FORMAL PLANNING OBJECTION

State Significant Development Application

Reference: **SSD-93020230**

Proposed Development: 40–48 Redan Street, Mosman NSW 2088

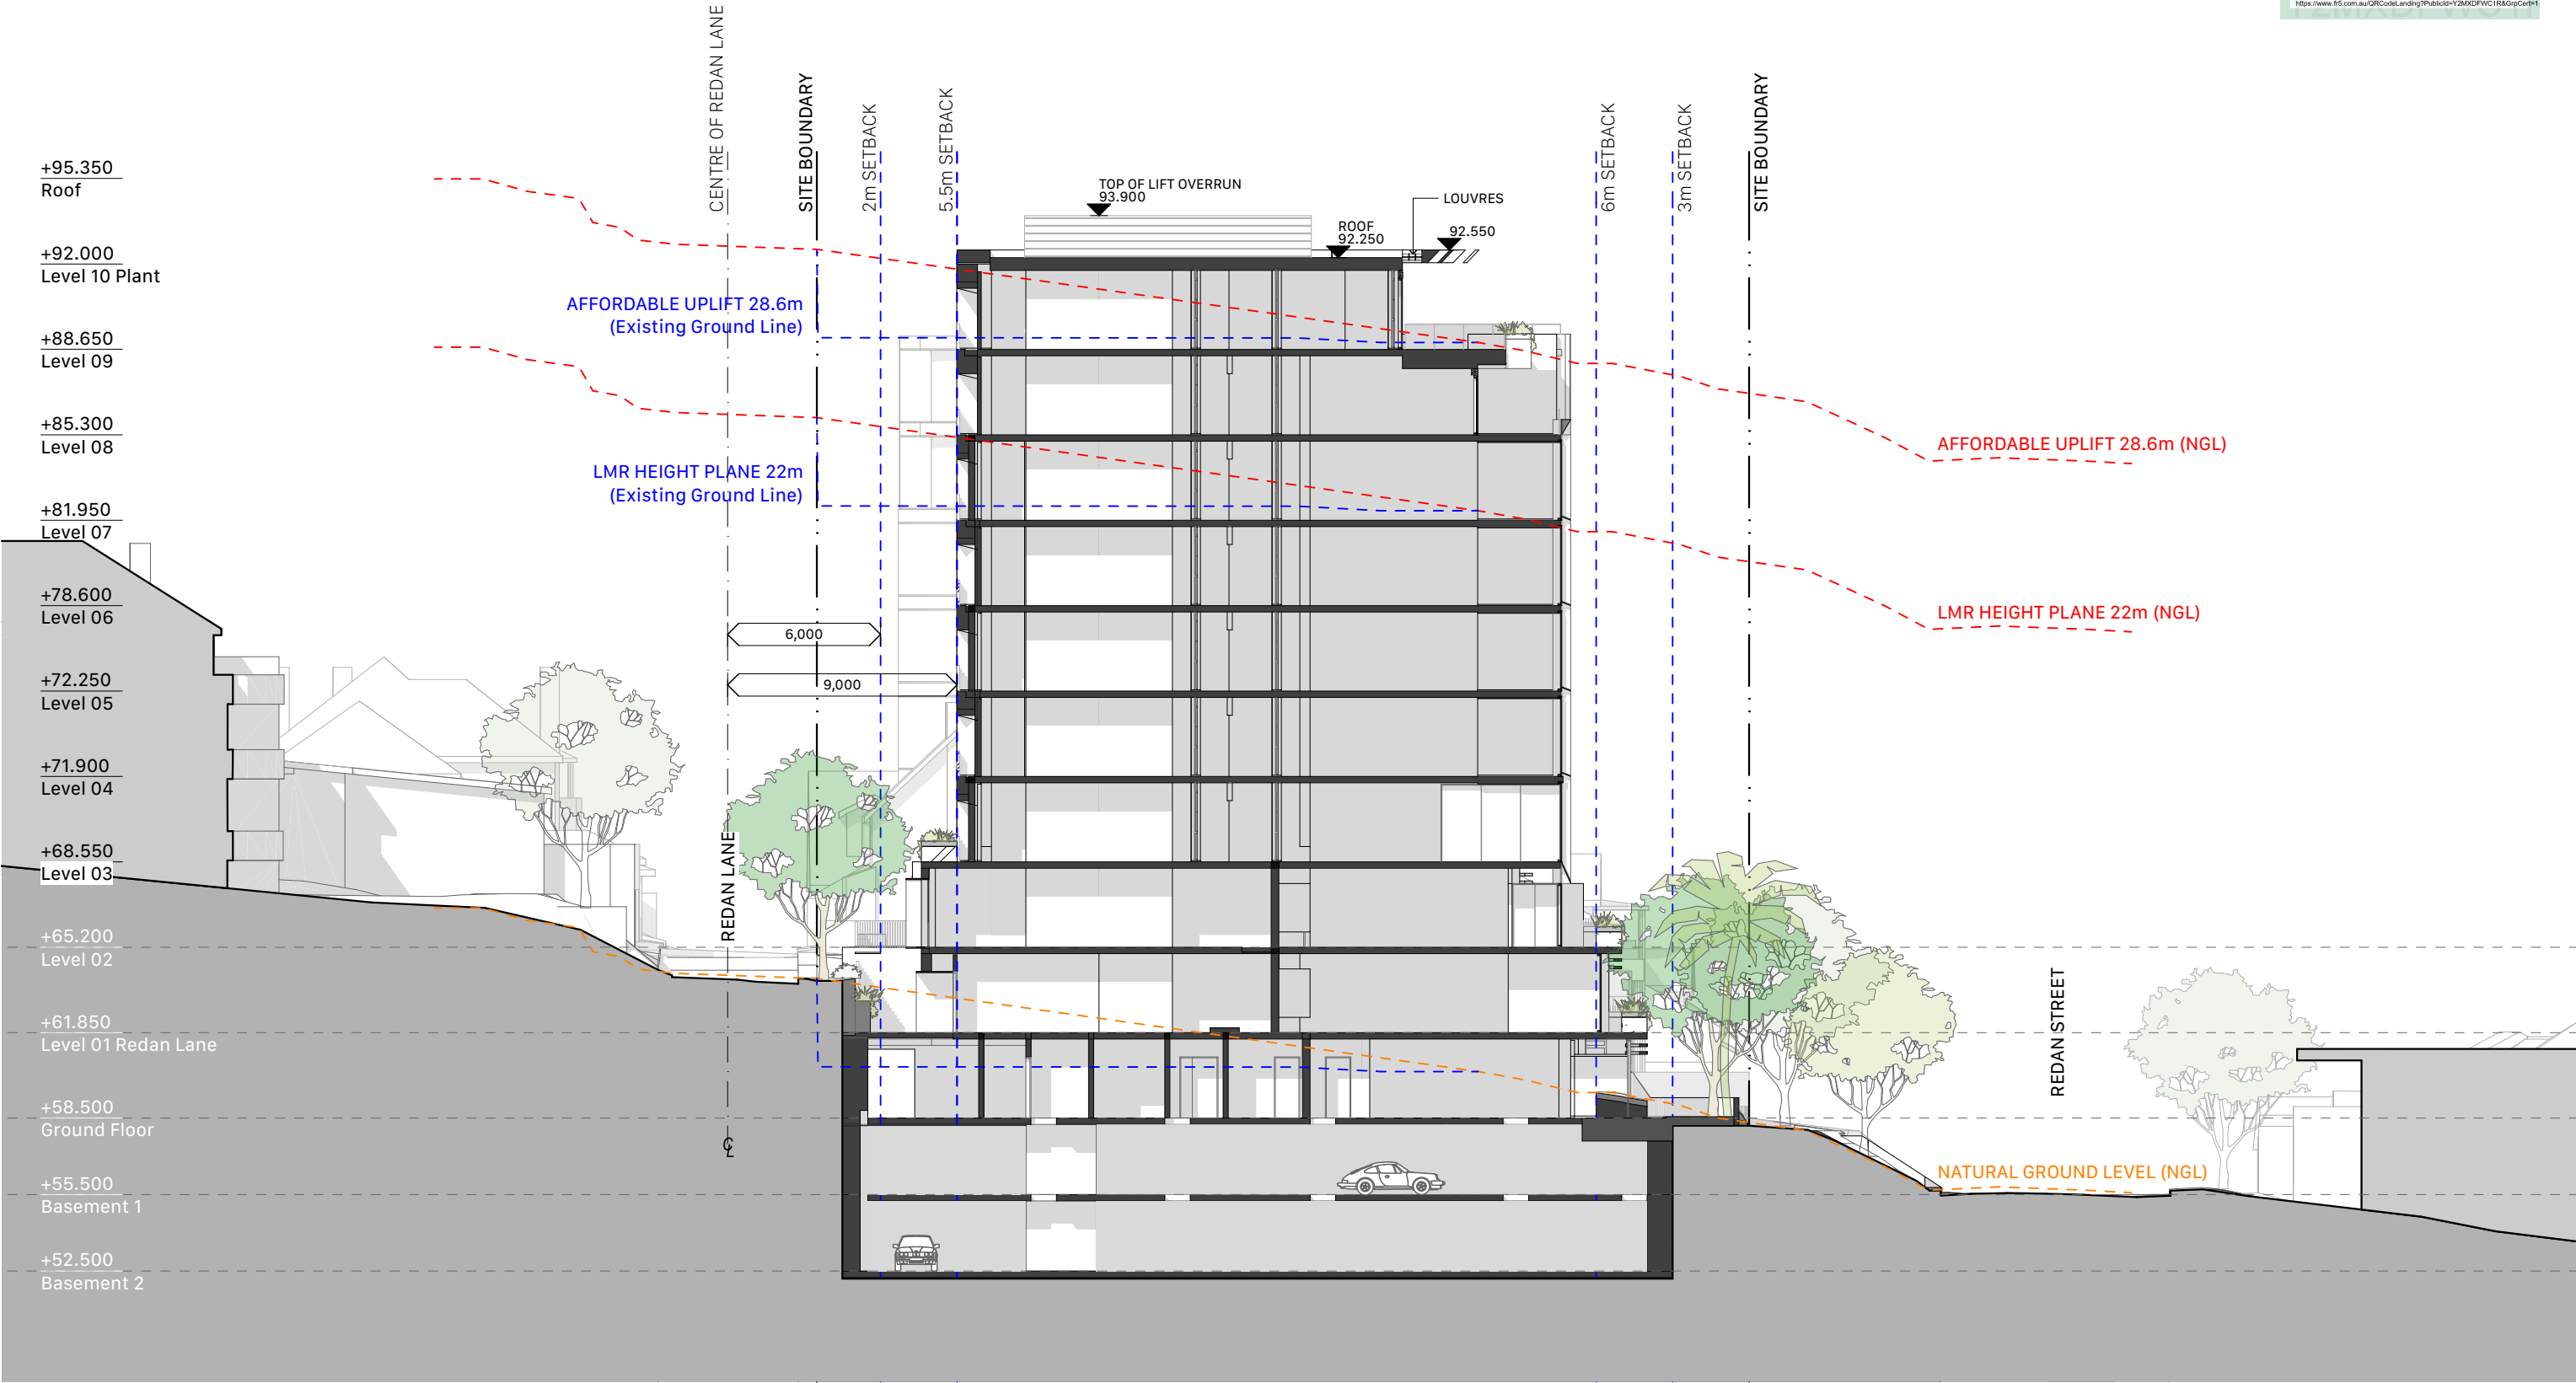
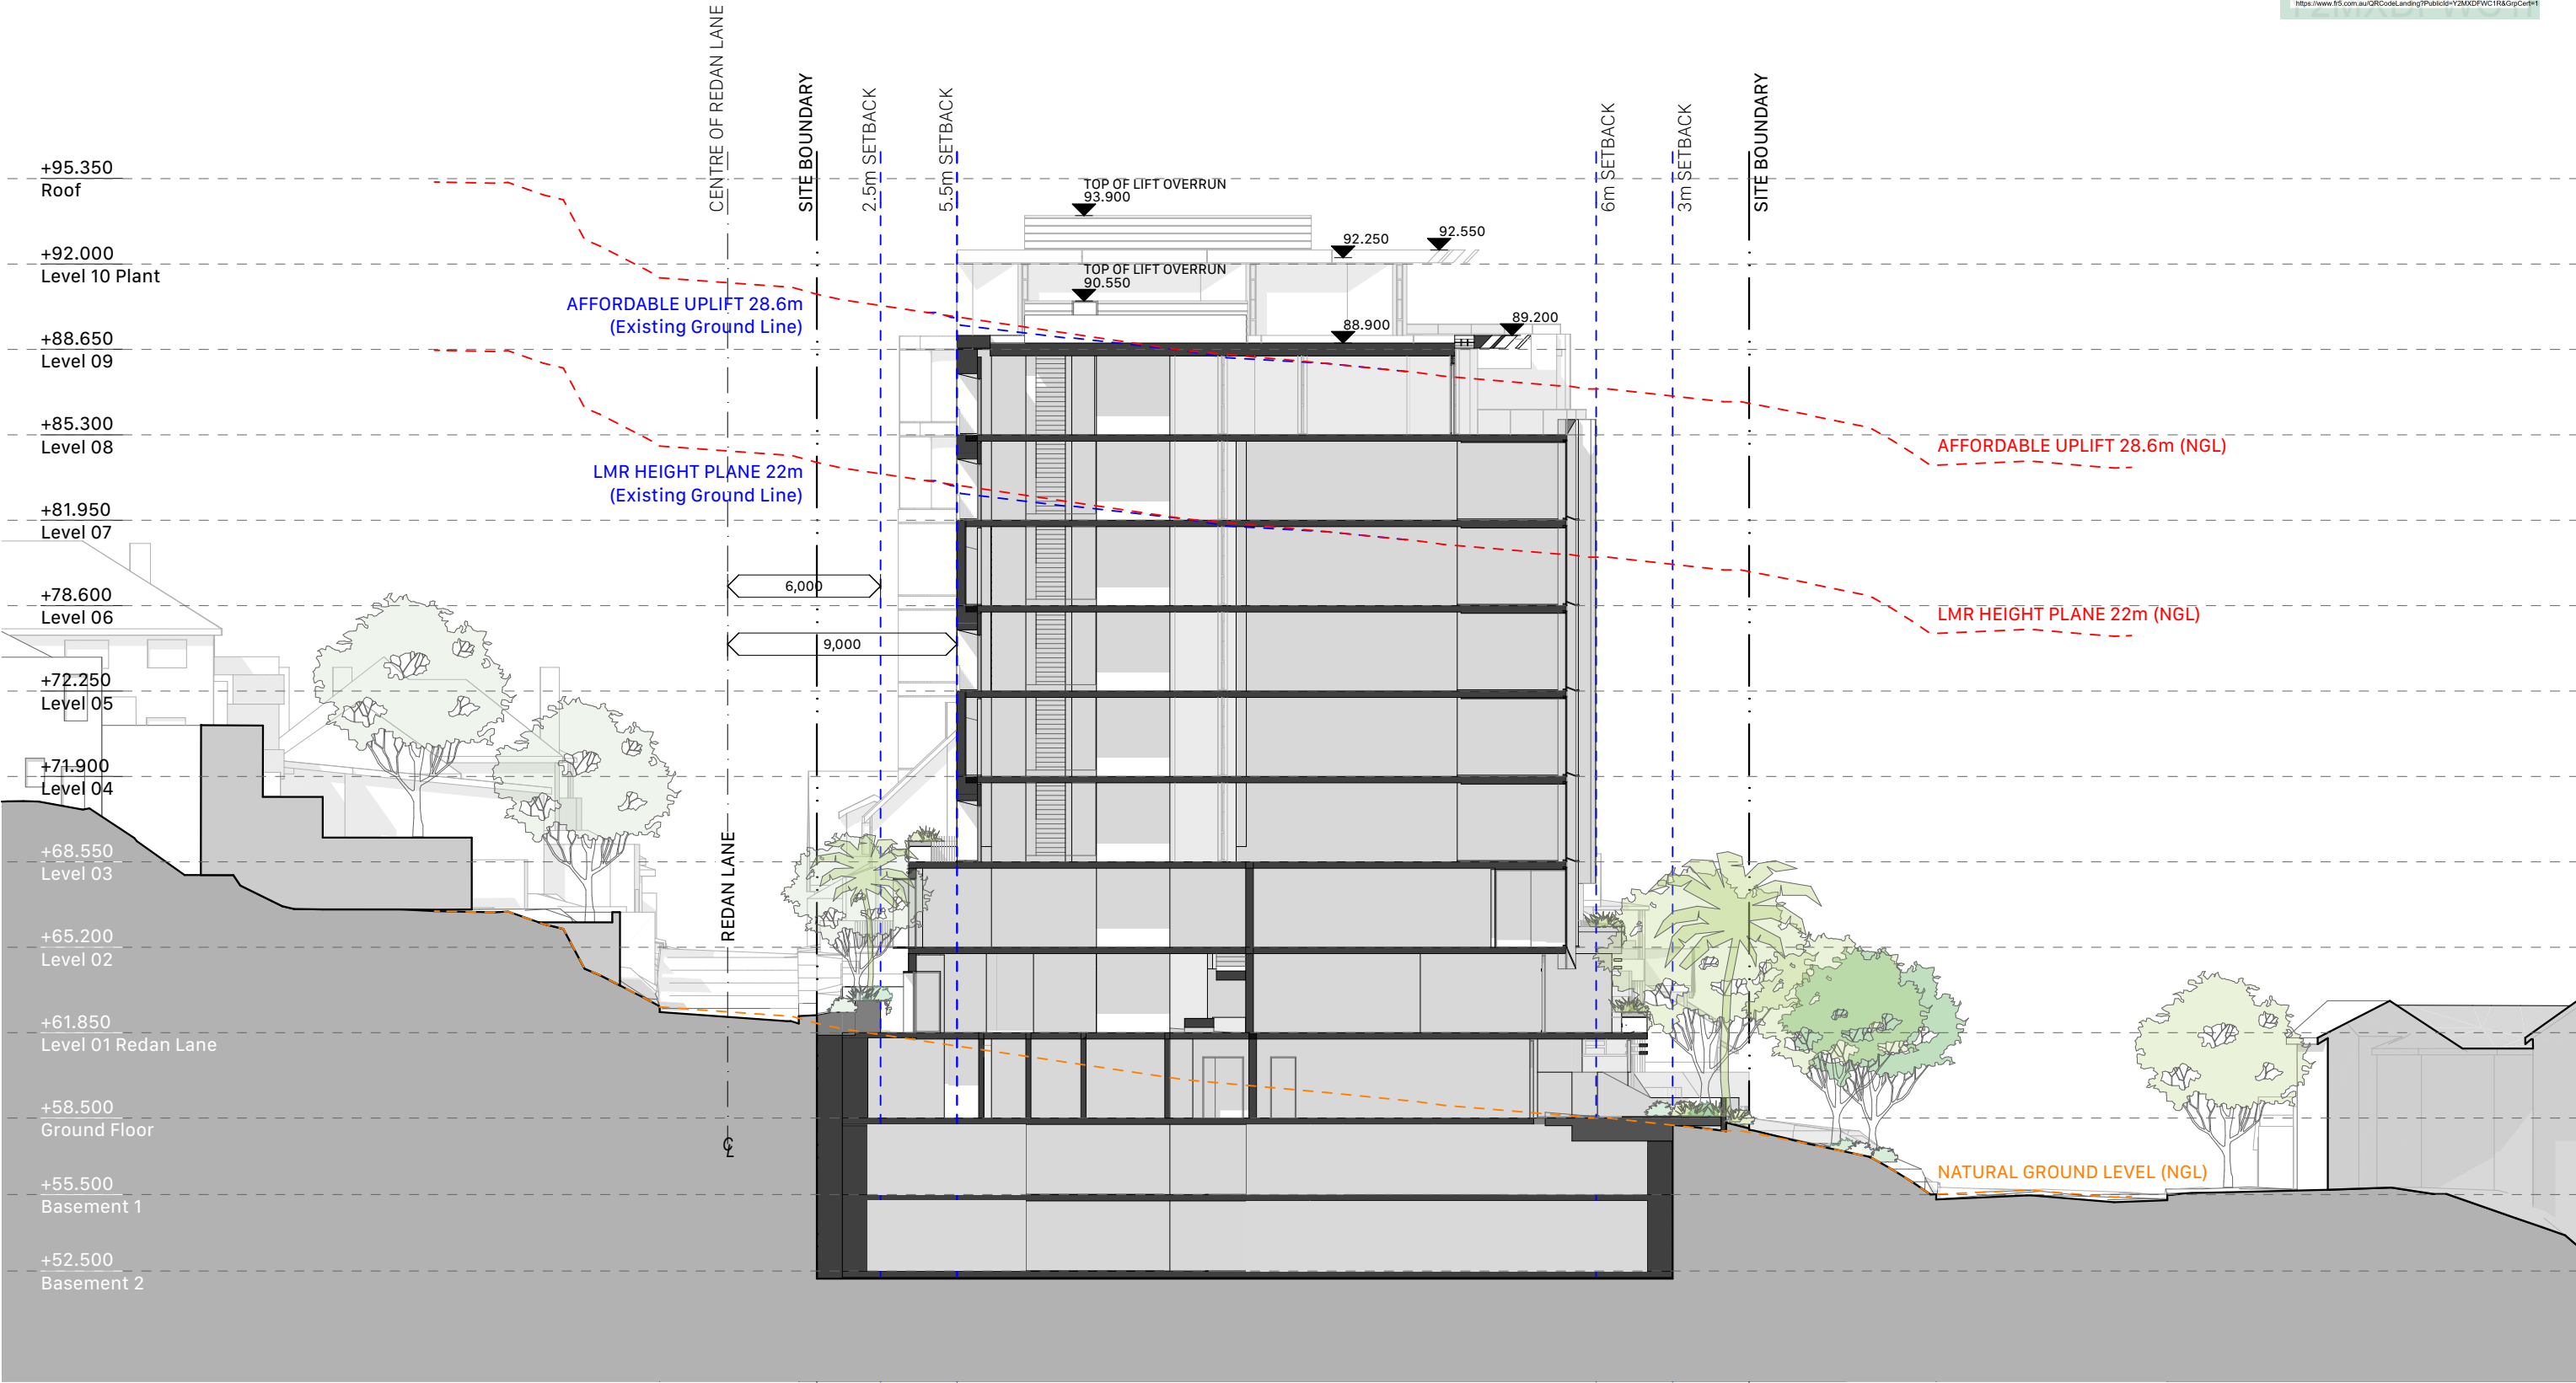
This characterisation is demonstrably false. The architectural drawings in the application - Appendix B of the EIS - show clearly that land falls to the east of the development site. The site is in a mid-slope condition, not on a ridgeline. This is not a matter of interpretation. It is a fact that can be verified by examining the plans the applicant has lodged.

Because the topography misrepresentation underlies both the Visual Impact Assessment and the shadow and privacy analysis in the EIS, it contaminates the reliability of those assessments. The Department should require the applicant to resubmit both assessments based on an accurate representation of the site's topographic position before any further assessment of the application proceeds.
